File: SF18/82638
Job ID No: DOC18/707206
Your Ref: SSD8517

RE: Response to Amendment request for Australian Technology Park (ATP) Eveleigh, Design amendments to Locomotive Workshops Bays1-4a; and, amendments to the Public Domain (SSD 8517)

- Bays 1-4a Locomotive Workshops internal amendments include:
 - Relocation and reduction in size of plant from Level 1;
 - Reconfiguration and removal of the fire stair for provision of plant room;
 - Reconfiguration of public access lift and Back of House area of Loading Dock;
 - Reconfiguration of tenancy in Bays 1-2 (Mezzanine Level) & Bays 3-4a (Level 1).
- Public Domain (Locomotive Street) amendments include:
 - Relocation of two accessible parking spaces;
 - Provision of additional loading space and relocation of one space;
 - Removal of one taxi and one drop off space;
 - Reversing proposed change (lowering turntable) to the western turntable.

Figure 9 Locomotive Street

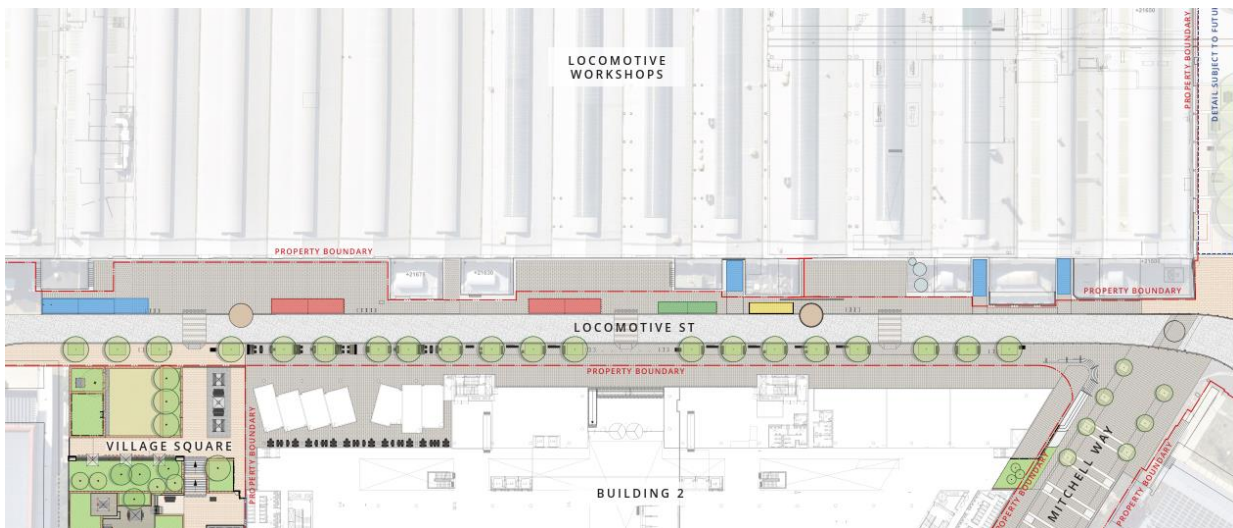
However, the relocation of two accessible parking spaces (proposed to be perpendicular to Bay 14) has the potential to increase the risk of vehicular impact to the Locomotive Workshops building. It is therefore suggested that the proposed accessible spaces be reconsidered and relocated elsewhere.

We also note a truck swept path for a large articulated vehicle on Locomotive Street, which indicates the use of this street for servicing purposes. The swept path is shown avoiding the southern turntable however in reality it is likely the truck will proceed over this element. The documentation provided does not include a structural assessment. A structural assessment should be undertaken to ascertain whether any strengthening is required to avoid heritage impacts to the southern turntable or any other heritage impacts by the proposed traffic flows.
